**Re: Westpointe Data Center at 8401 Daytona Rd. NW
Erosion and Sediment Control Plan
Engineer's Stamp Date – 10/2/24 (K09E026D)**

Based on the information in your submittal, received on 10/8/24, the above-referenced ESC Plan cannot be approved until the following comments are addressed.

DESIGN REVIEW COMMITTEE	CITY ENGINEER APPROVAL	ZONE MAP NO.
		J-09-Z & K-09-Z
		CITY PROJECT NO.
		655779
		SHEET NO.
		ESC - 003

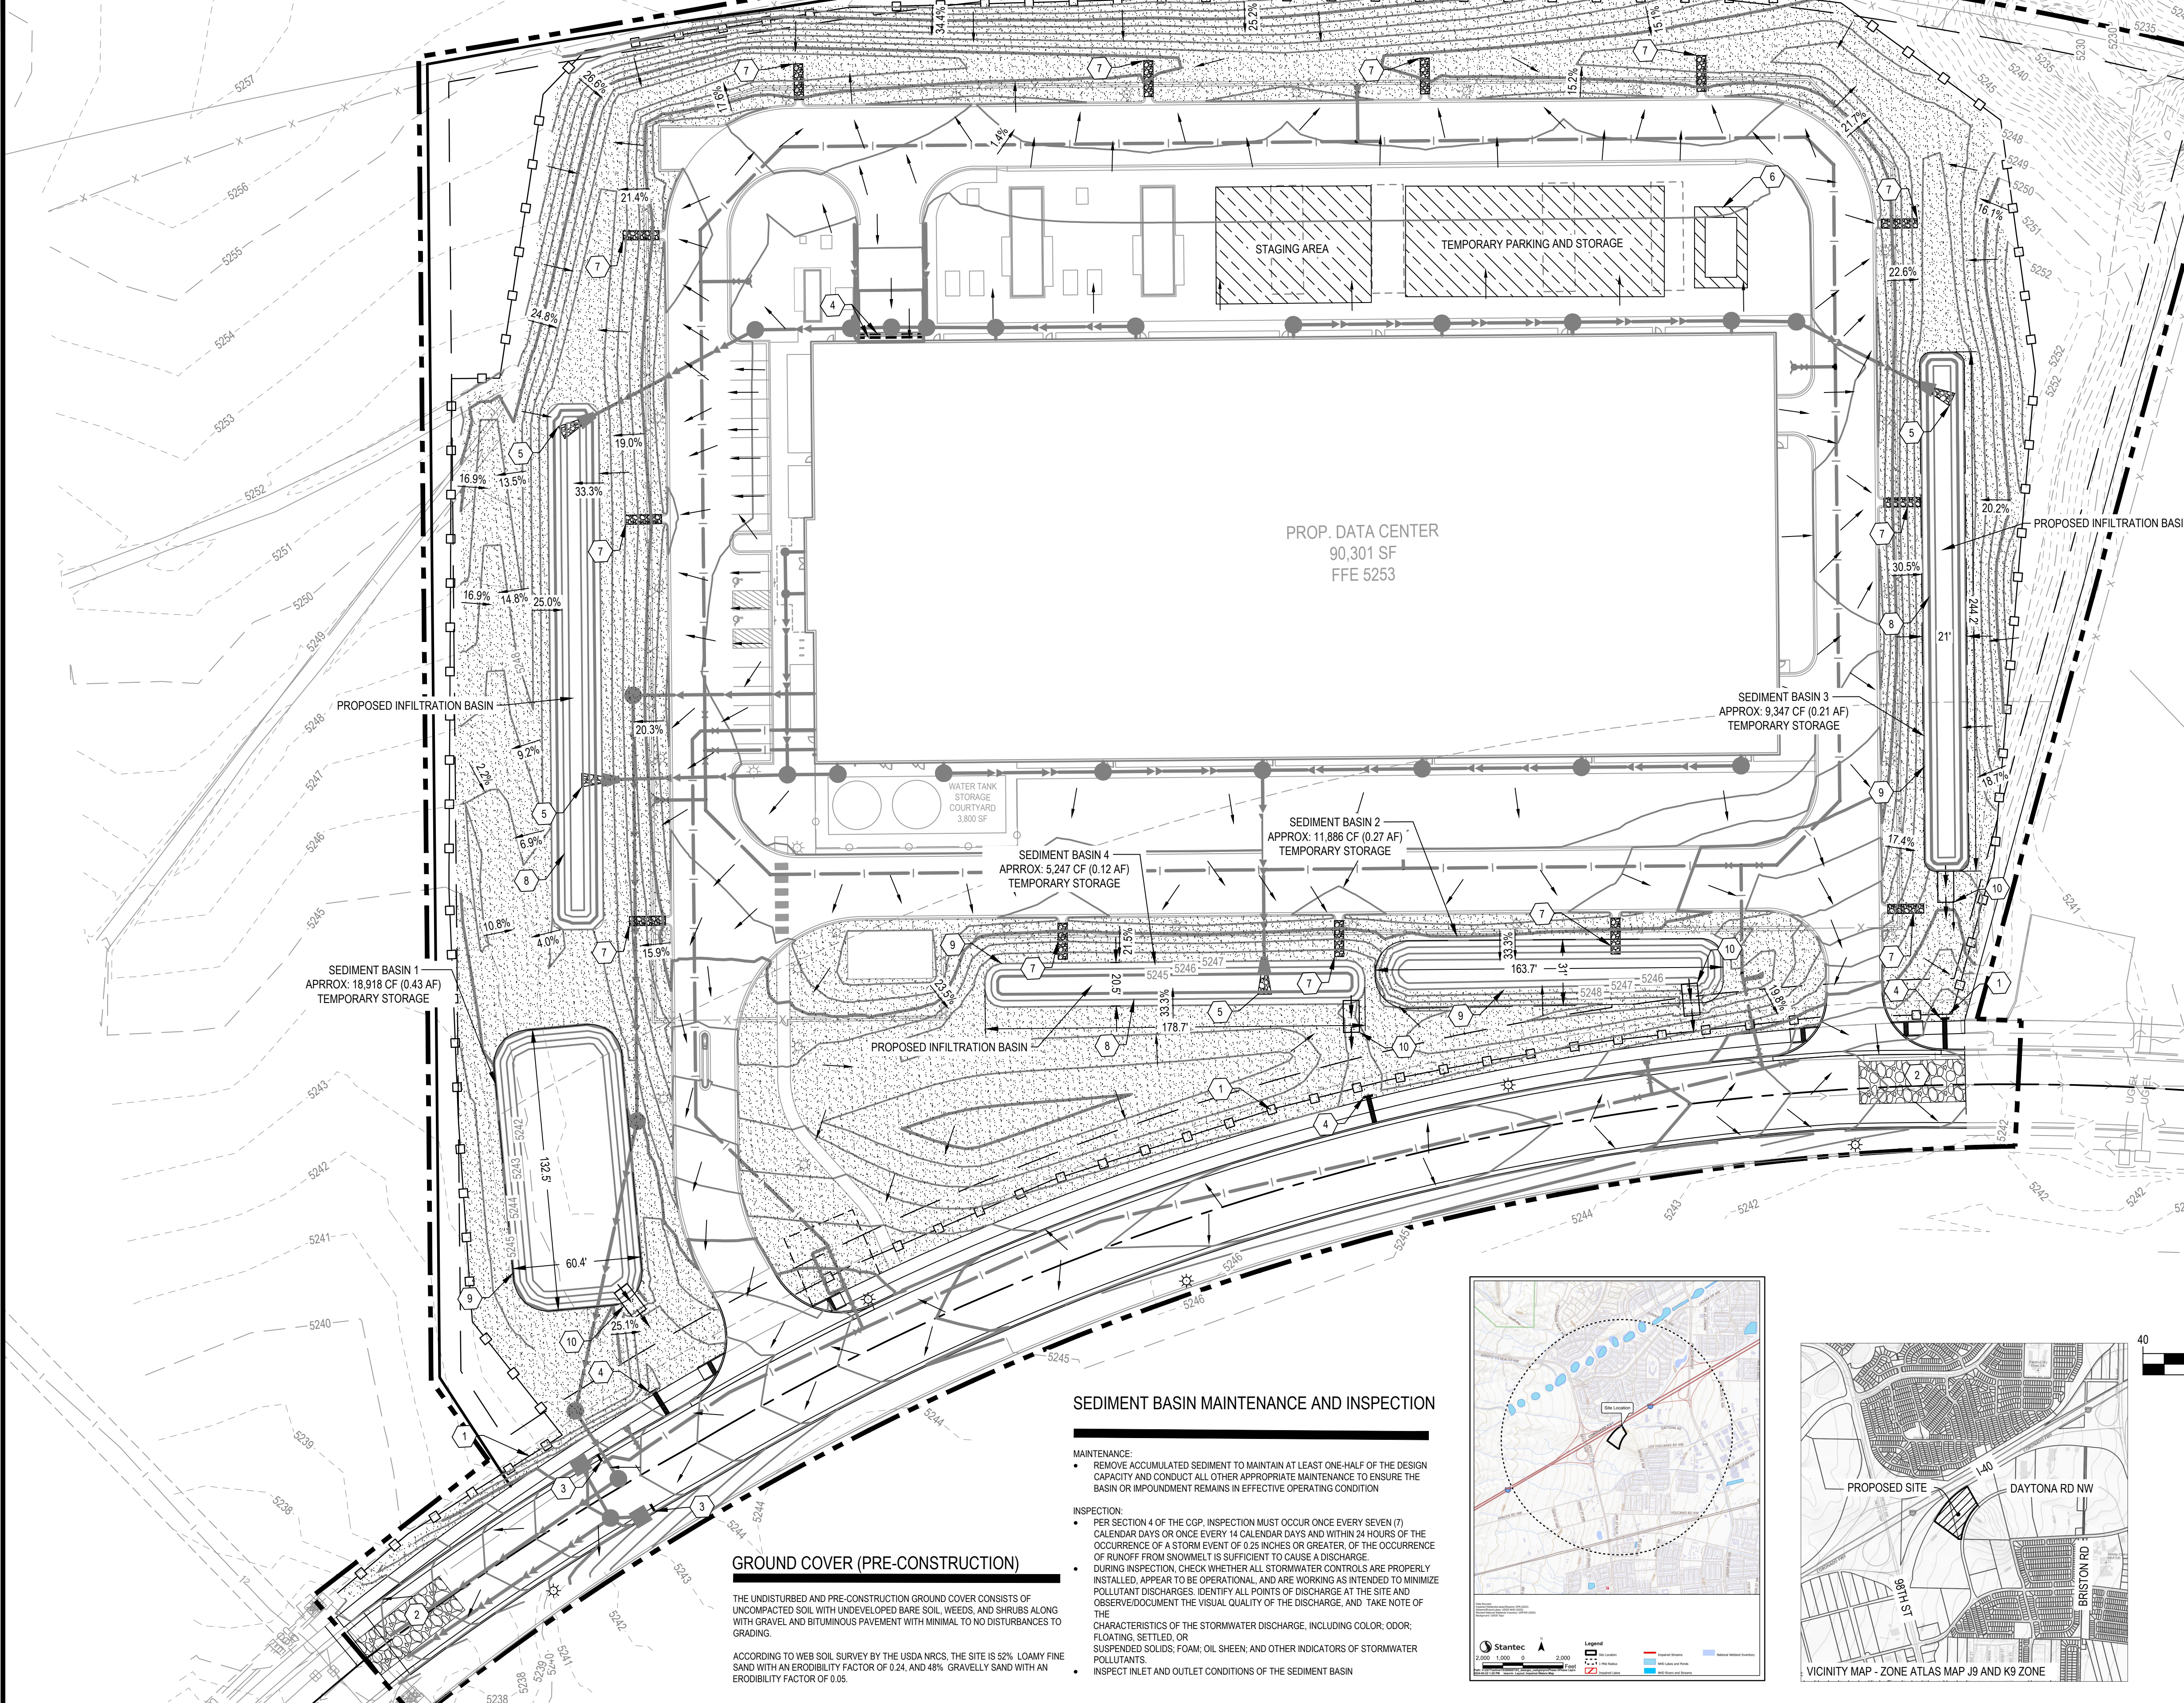
4. The heavy hatch pattern still obscures contours and should be moved to a separate sheet from the rest of the information that is required on the ESC Plan. The hatch pattern isn't identified in the legend, but it appears to be some kind of final cover. Please consider deleting the hatch if final cover is per an officially approved "Landscape Plan" as referenced by Erosion Control note #10 and Grading note #5 on sheet ESC-002. I can't find the requested temporary diversion berms on the ESC Plan, but they may be obscured by the heavy hatch pattern.

5. Temporary diversion berms or swales must be indicated on the ESC Plan as the first items of construction along the southwest and northeast (downhill) edges of the site to direct the stormwater into the sediment basins. A symbol should be added to the legend, locations shown on the plan view, a detail added to the detail sheet, and a BMP Maintenance note added to sheet ESC-02. Just showing swales with the final contours doesn't get temporary controls constructed as first items.

6. The table of sediment basin calculations and dimensions is too small. The Minimum lettering size is 0.1". Please make it clear that these are the first items of construction and identify a schedule for removal of the BMPs at after construction and stabilization are complete. Identify which sediment basins will be removed, modified, and/or remain in place as post construction SWQ ponds.
7. Please change the title of sheet ESC-003 from "Post Construction" to "Temporary ESC" (during construction) Plan.
8. Update the engineer's signature & date on all sheets each time the plan changes.
